Principal Areas of Disagreement Summary Statement (PADSS)

This statement has been prepared by Horsham District Council (“the Council”) with input from the joint local authorities, technical consultants and legal specialists. The Northern Runway Project application was submitted to the Planning Inspectorate on 6 July 2023 and accepted for Examination on 3 August 2023. The Council is one of the local authorities identified by Section 43(2) of the Planning Act 2008 and in response to the Examining Authority’s Procedural Decision letter of 8 September 2023 to the Applicant and the Host and Neighbouring Authorities, the Council has prepared this Principal Areas of Disagreement Summary Statement (“PADSS”) (Version 1). This Statement identifies the initial principal areas of disagreement and is provided only as a summary position at this pre-examination stage. The Council appreciates this document is long; however, its length is a reflection of the scale of its major concerns with the application. In the light of these concerns, the Council considers the length of the document to be reasonable.

Diagram 3.3.9: Model performance before and after adjustment, London zone

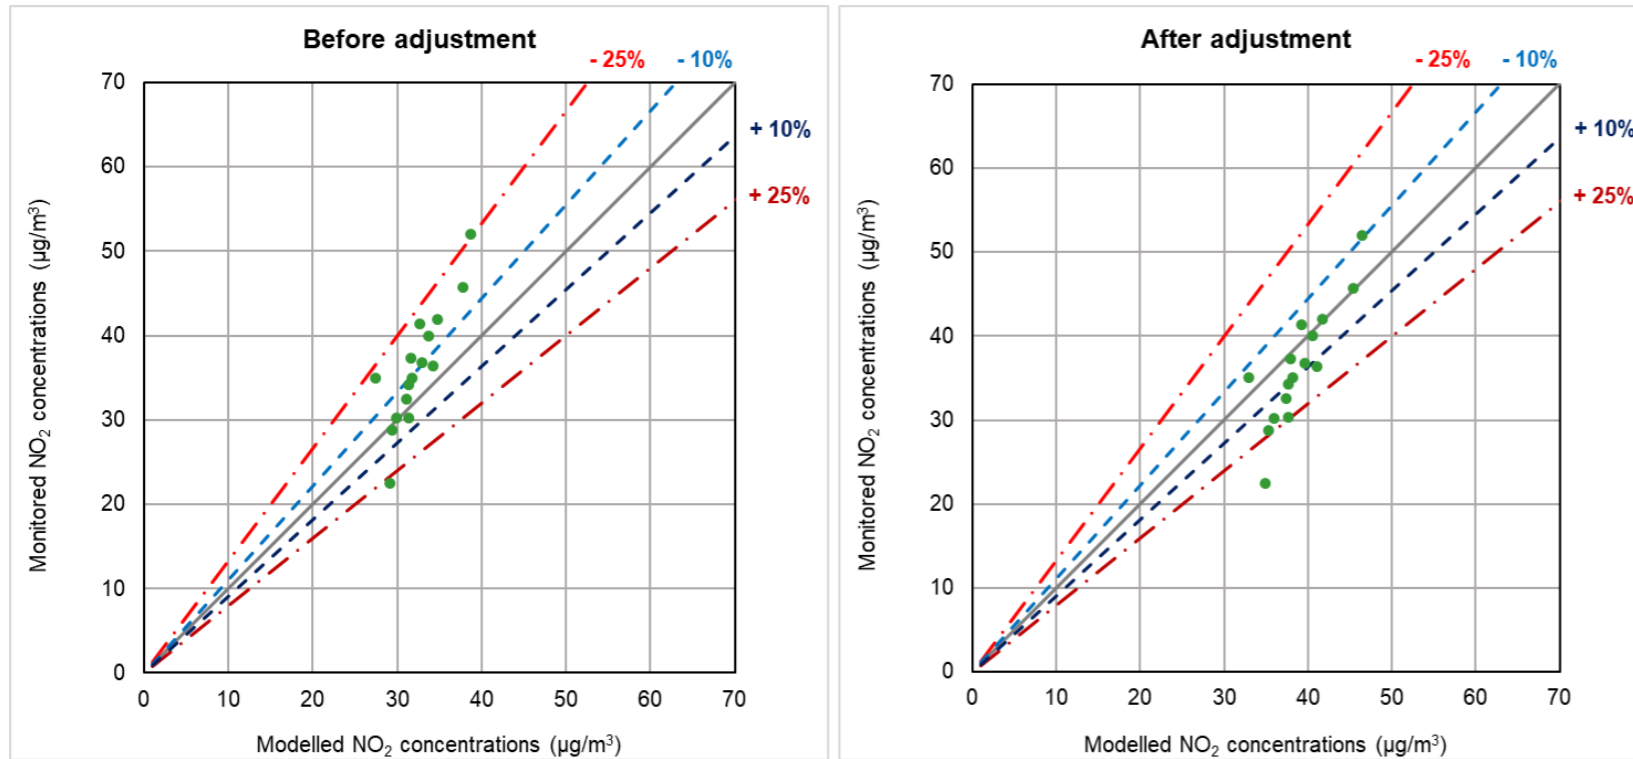
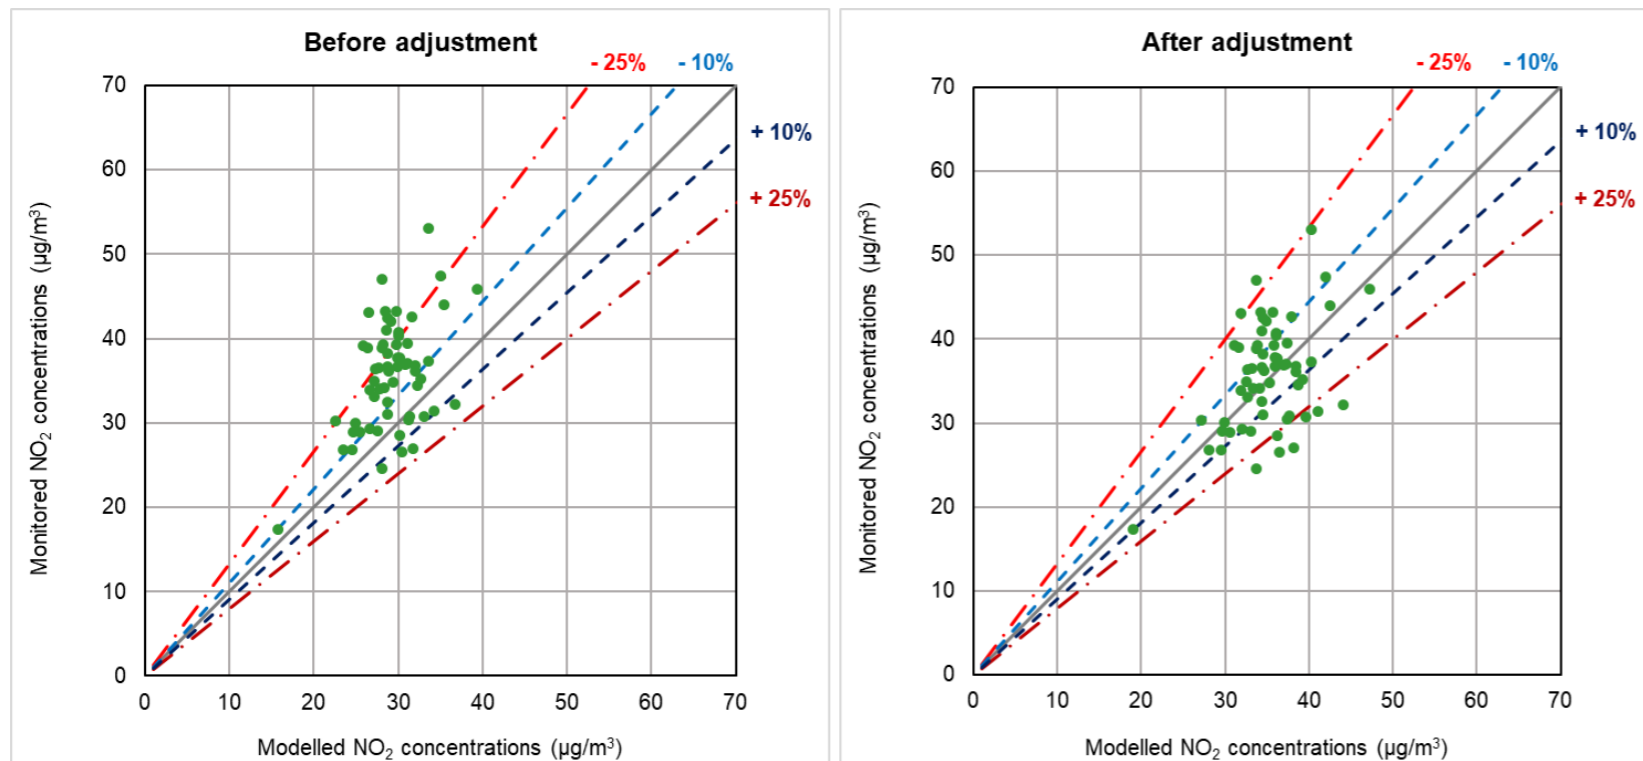
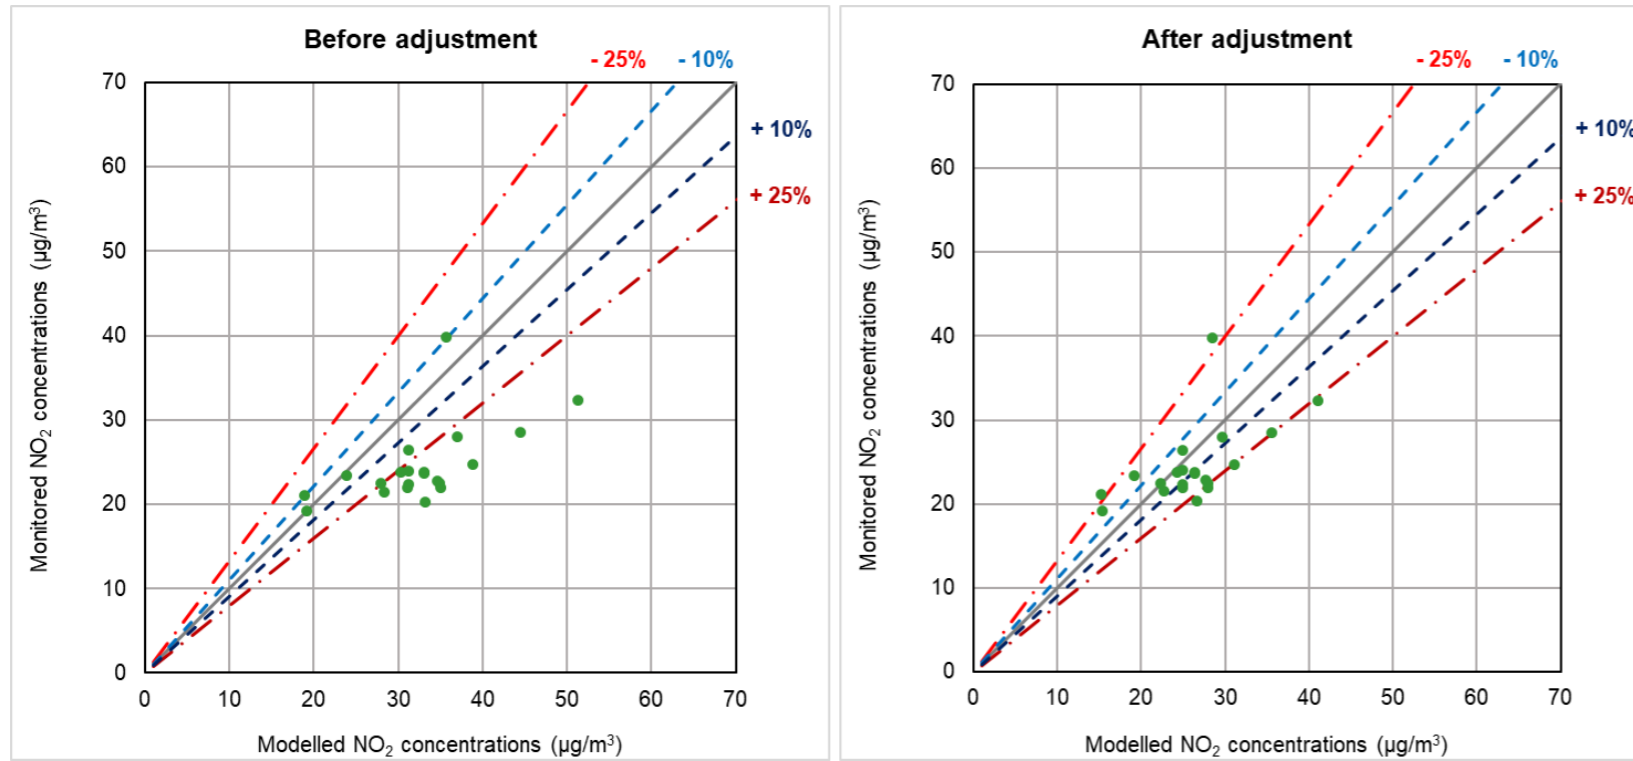
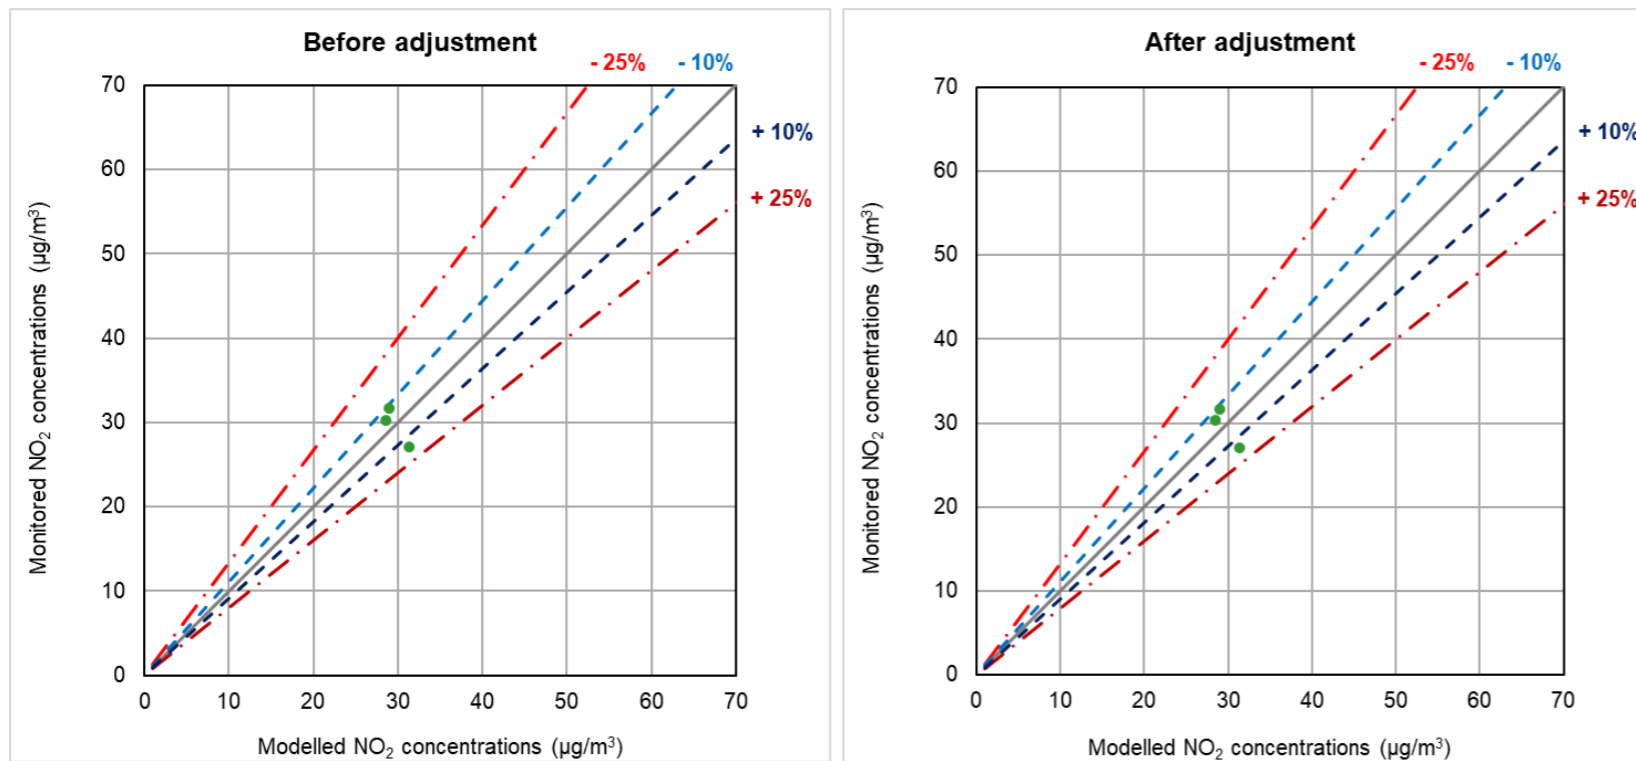
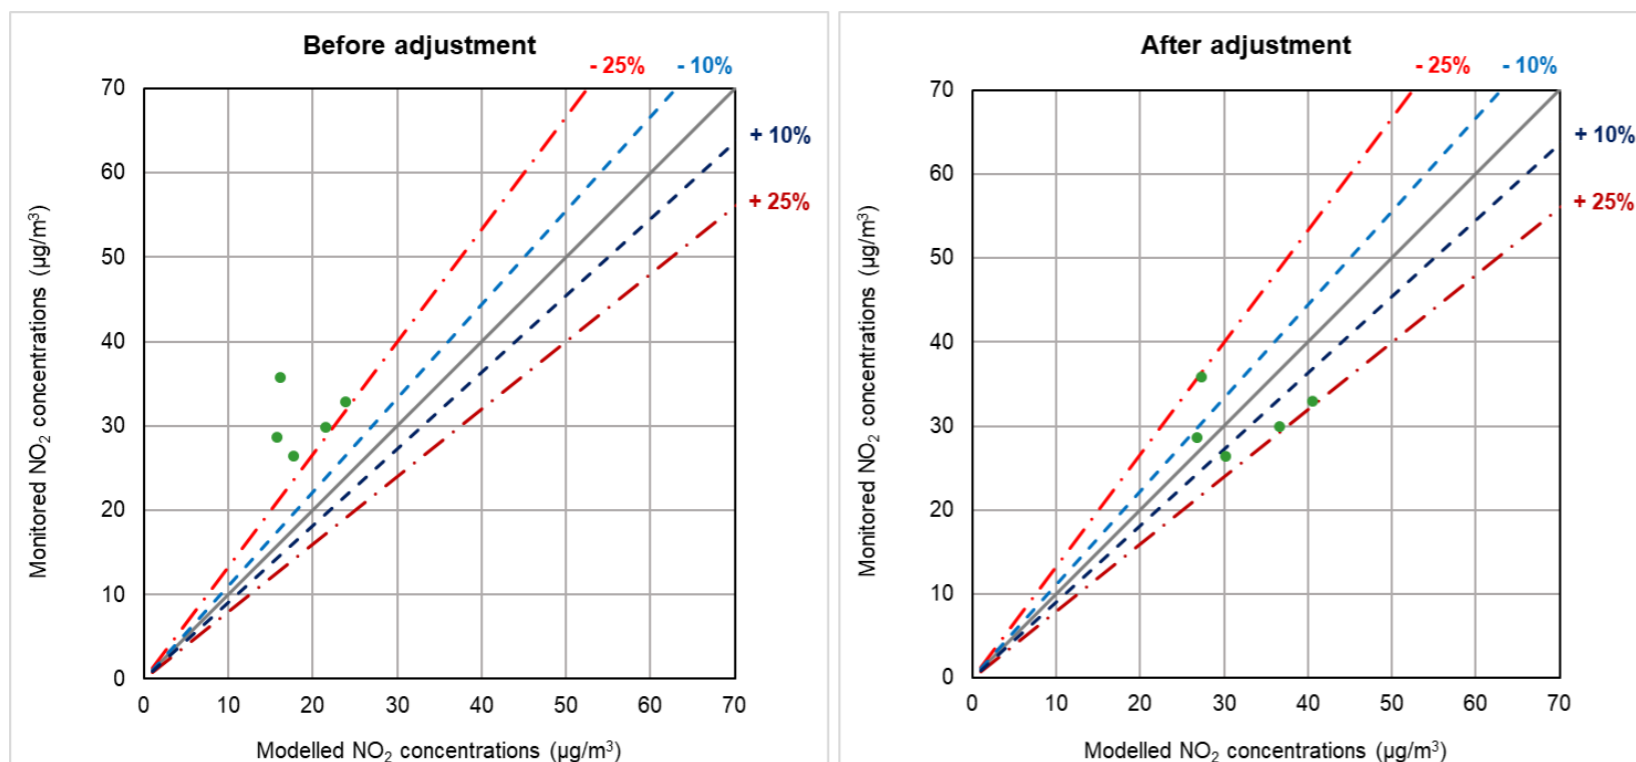
3.5	<p>Model Set Up and Methodology</p>	<p>Regarding model verification, Appendix 13.6.1: Air Quality Data and Model verification is missing details on how model verification factors for the selected zones were established. Details are required of the initial verification including Monitored Road NOx Contribution versus Unverified Modelled Road NOx, which monitoring sites were used, and which were removed from the verification process.</p> <p>To facilitate the scrutiny of the model set up and any assumptions used, it is requested that a complete set of input files be shared for 2018 (Base Year) and 2029 (nearest future year). In addition, Operational and Construction impacts for 2029 should be modelled jointly as one scenario,</p>	<p>The Applicant should provide further details in relation to the model verification</p>	Uncertain
